**KIRKLEES METROPOLITAN COUNCIL
INVESTMENT & REGENERATION SERVICE**

DELEGATED DECISION TO DETERMINE PLANNING APPLICATIONS

Reference No:	2025/62/91466/E
Site Address:	11B, Kingsway, Birstall, Batley, WF17 9LH
Description:	Erection of two storey side extension and rear, front/side dormers
Recommending Officer:	Jennifer Booth

DECISION - REFUSED

Client: Graham Teale	
11B Kingsway - Birstall PROPOSED FLOOR PLANS & ELEVATIONS	
Scales: 1:50 1:100 @ A1	Date: May 25
Drawing Number: 2025-059-03	Revision: -
Drawn by: DCK/KLU

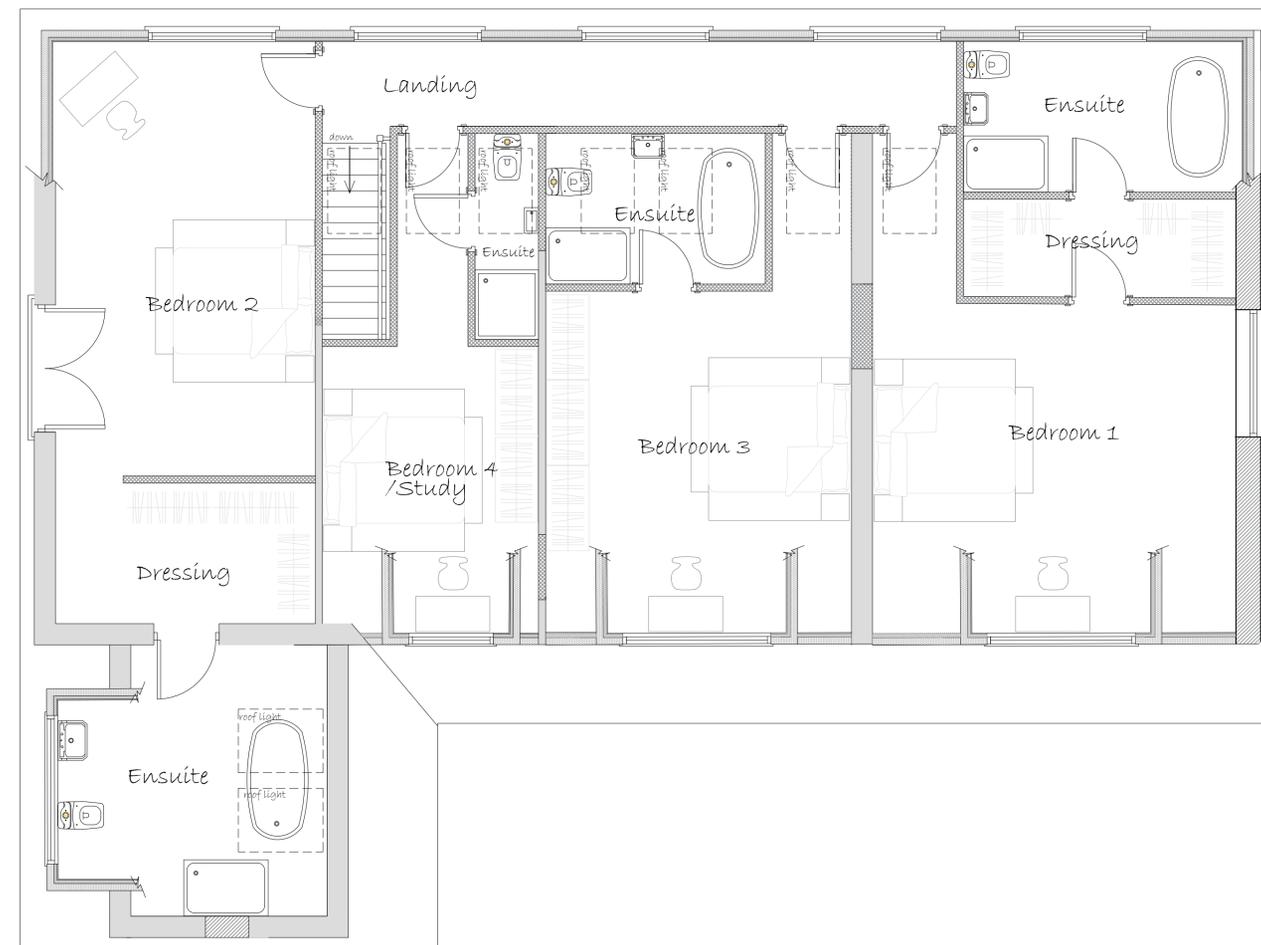
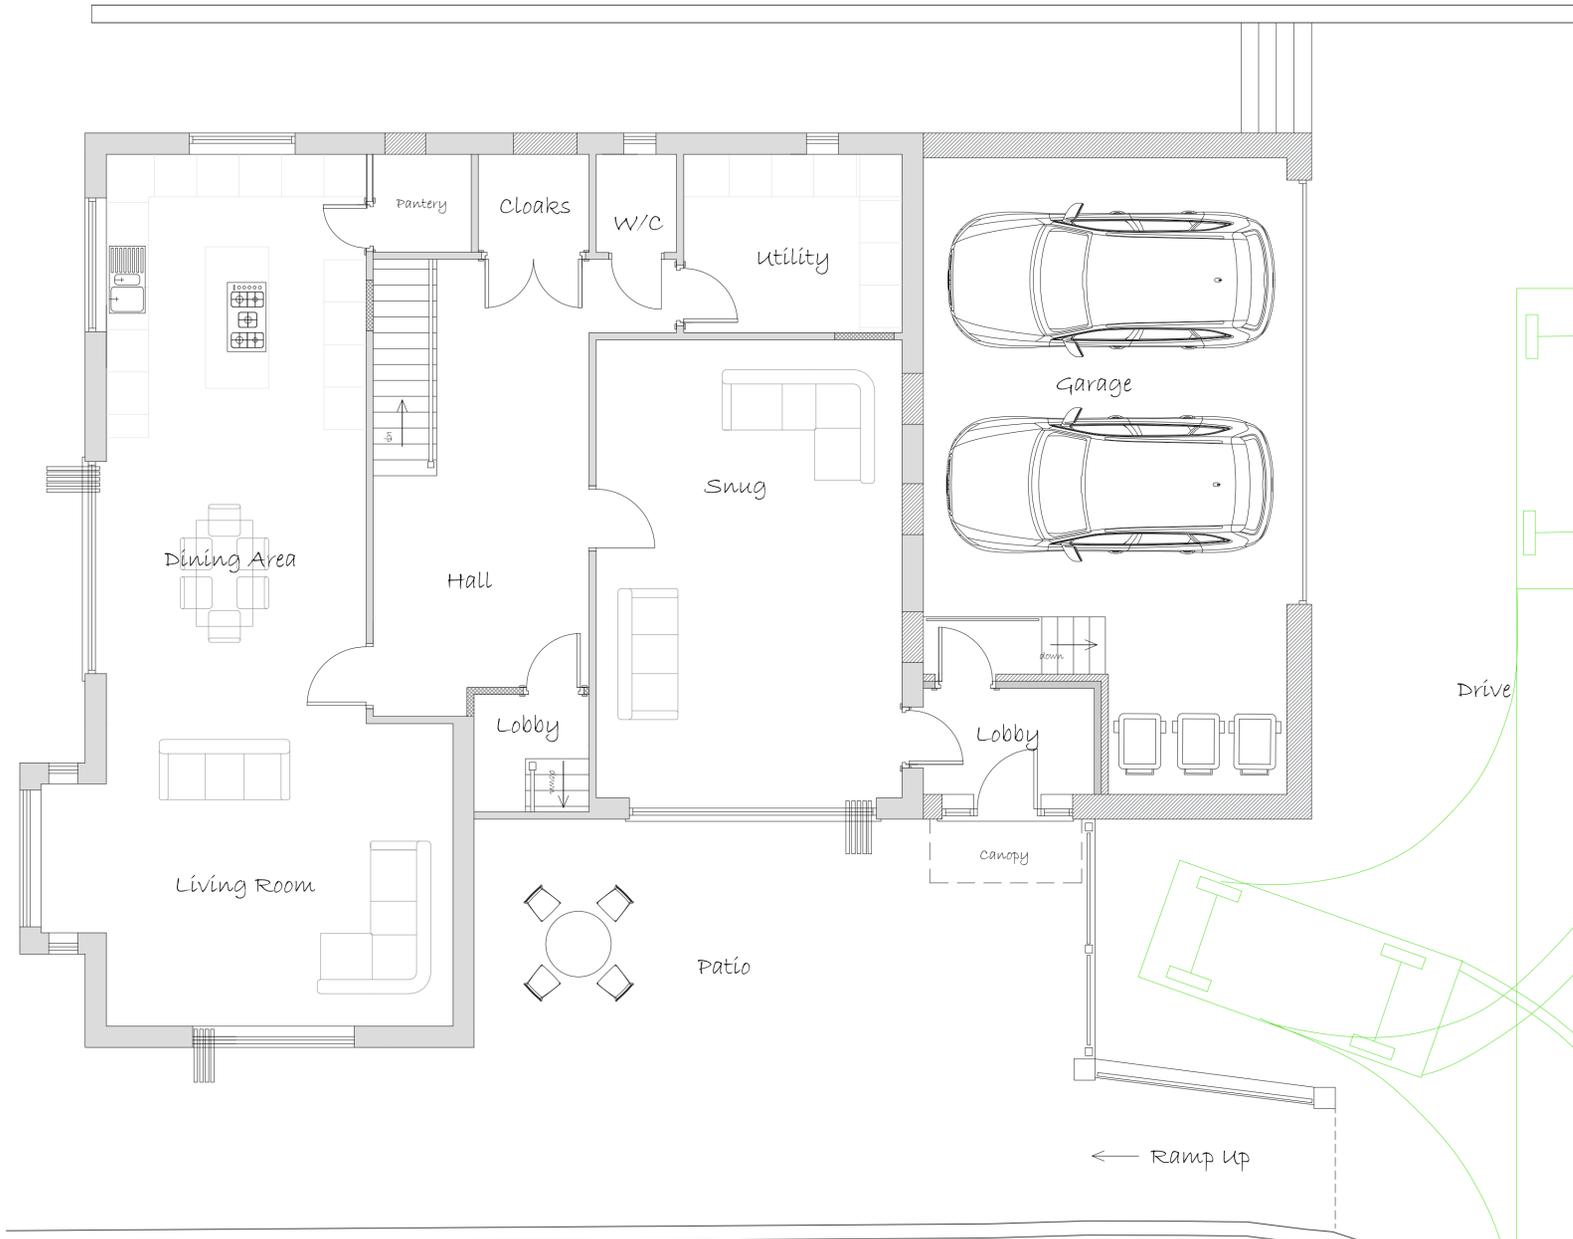
The proposal includes the replacement of the existing front dormer with four new dormers—one positioned within the roof plane of the front extension and three within the main roof slope. The proposed dormers vary in size and spacing, resulting in an irregular and visually unbalanced arrangement. Despite the use of vertically hung tiles to match the existing materials, the cumulative impact of the dormers would create a cluttered and incongruous appearance that fails to respect the architectural character of the host property. As such, the development would be detrimental to the visual amenity of the street scene.

The proposed rear dormer, by virtue of its very substantial size, would appear overly dominant and would not form a subservient addition to the dwelling. Its scale and massing would disrupt the proportions of the rear roof slope, resulting in a visually intrusive feature. When considered alongside the proposed front dormers, the cumulative impact of the development would lead to a cluttered and incongruous appearance that fails to respect the character of the host property. As such, the proposal is considered to result in harm to the visual amenity of the dwelling and its wider setting.

The proposed front, side, and rear dormers, by virtue of their cumulative scale, positioning, and design, would result in an awkward and cluttered roofscape. This would form a visually intrusive and incongruous addition that fails to respect the character and appearance of the host dwelling. The development is therefore considered to cause unacceptable harm to the visual amenity of the property and the surrounding area. To permit the proposals would be contrary to Policy LP24 of the Kirklees Local Plan, KDP1 & KDP2 of the House Extension & Alteration SPD and Chapter 12 of the National Planning Policy Framework.

1. The proposed front, side, and rear dormers, by virtue of their cumulative scale, positioning, and design, would result in an unsympathetic cluttered roofscape. This would form a visually intrusive and incongruous addition that fails to respect the character and appearance of the host dwelling. The development is therefore considered to cause unacceptable harm to the visual amenity of the property and the surrounding area. To permit the proposals would be contrary to Policy LP24 of the Kirklees Local Plan, KDP1 & KDP2 of the House Extension & Alteration SPD and Chapter 12 of the National Planning Policy Framework.
